**PROPOSED REGIONAL DISTRIBUTION CENTRE
KELLOGG ROAD, ROOTY HILL
RINKER AUSTRALIA PTY LTD
RESPONSE TO ISSUES RAISED IN SUBMISSIONS TO EAR**

FEBURARY 2006

PROPOSED REGIONAL DISTRIBUTION CENTRE, KELLOGG ROAD, ROOTY HILL
RINKER AUSTRALIA PTY LTD
RESPONSE TO ISSUES RAISED IN SUBMISSIONS TO EAR

FIGURE 1

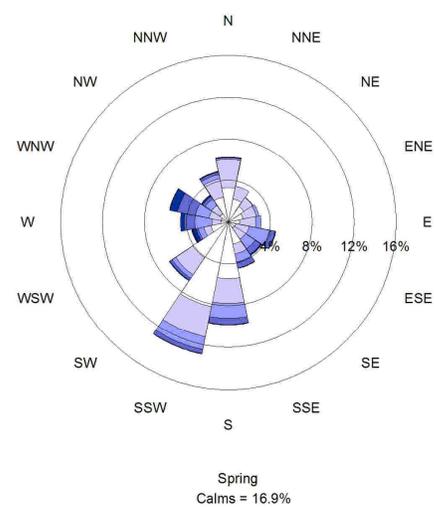
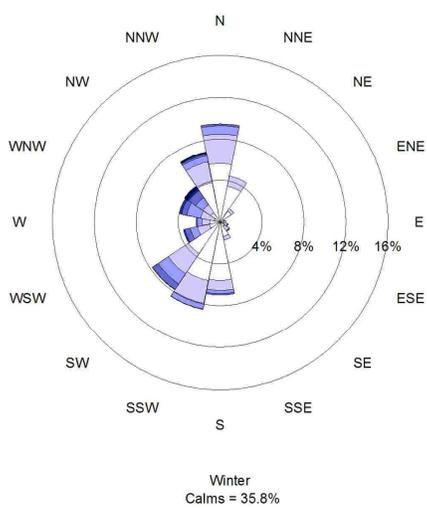
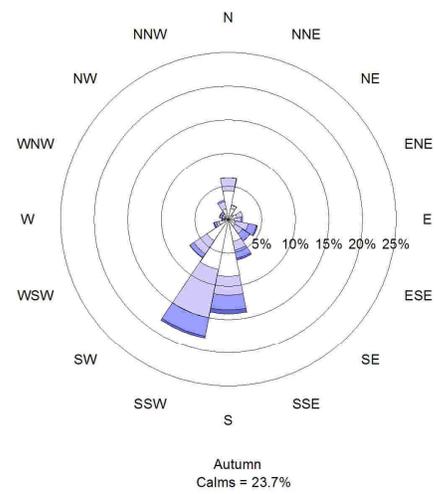
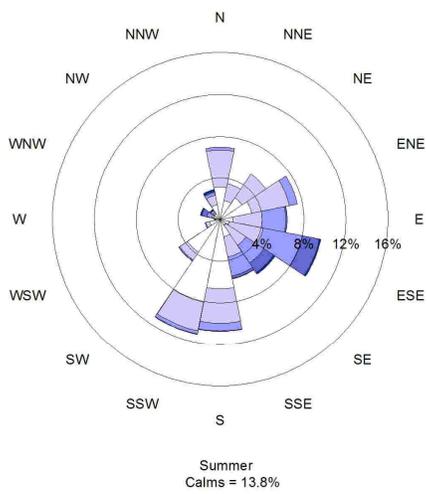
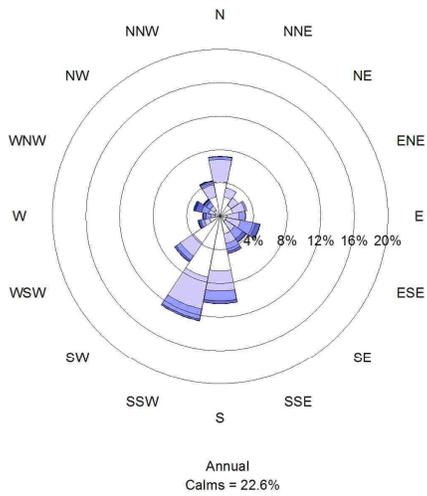
- Meteorological Data - What was the basis for use.	Meteorological data from both Blacktown and St Marys were investigated for the purposes of the assessment. It was brought to Holmes Air Sciences attention that the wind data from the Blacktown site may have been subject to increased turbulence due to tree growth in the area. St Marys data were therefore chosen for the modelling. The DEC was consulted and they advised that if the region concerned was further west of the ridge, then data from the St Marys station may be of more use. Holmes Air Sciences received comments from the Department of Planning (DoP) on the assessment report dated 30 June 2005. In their comments on the air quality assessment, the DoP requested more information on the cumulative impacts of 24-hour average PM_{10}. Further assessment was required which included modelling the operations with contemporaneous hourly PM_{10} monitoring data. Since the Blacktown site was slightly closer to the project site than St Marys, the Blacktown PM_{10} monitoring data were considered to be the most relevant. Contemporaneous meteorological and PM_{10} data from the Blacktown site were therefore used for the subsequent investigations (later provided in Appendix E of TR No 5).

No.	ISSUE	RESPONSE
		Windroses created from the St Marys and Blacktown wind data are presented in Figures 2 and 3 respectively (refer Appendix A). There are some differences in the measured wind patterns from each site and dispersion model results using both datasets are provided in Figure 4 (refer Appendix A). The dispersion model results from Figure 4 show that, for maximum 24-hour average PM_{10}, the predictions to the east and west of the site are very similar for both meteorological data records. It could be said that use of the Blacktown meteorological data results in slightly higher predictions to the east of the site. To the north and south of the site, use of the St Marys data gives slightly higher predictions than for the Blacktown data. It is noted that selection of St Marys meteorological data for the cumulative impact assessment (Appendix E of TR No 5) would have been more consistent with the main body of the report. However, the comparison presented here using both the St Marys and Blacktown meteorological datasets has shown the dispersion model results to be similar at the most sensitive (residential) areas around the site.
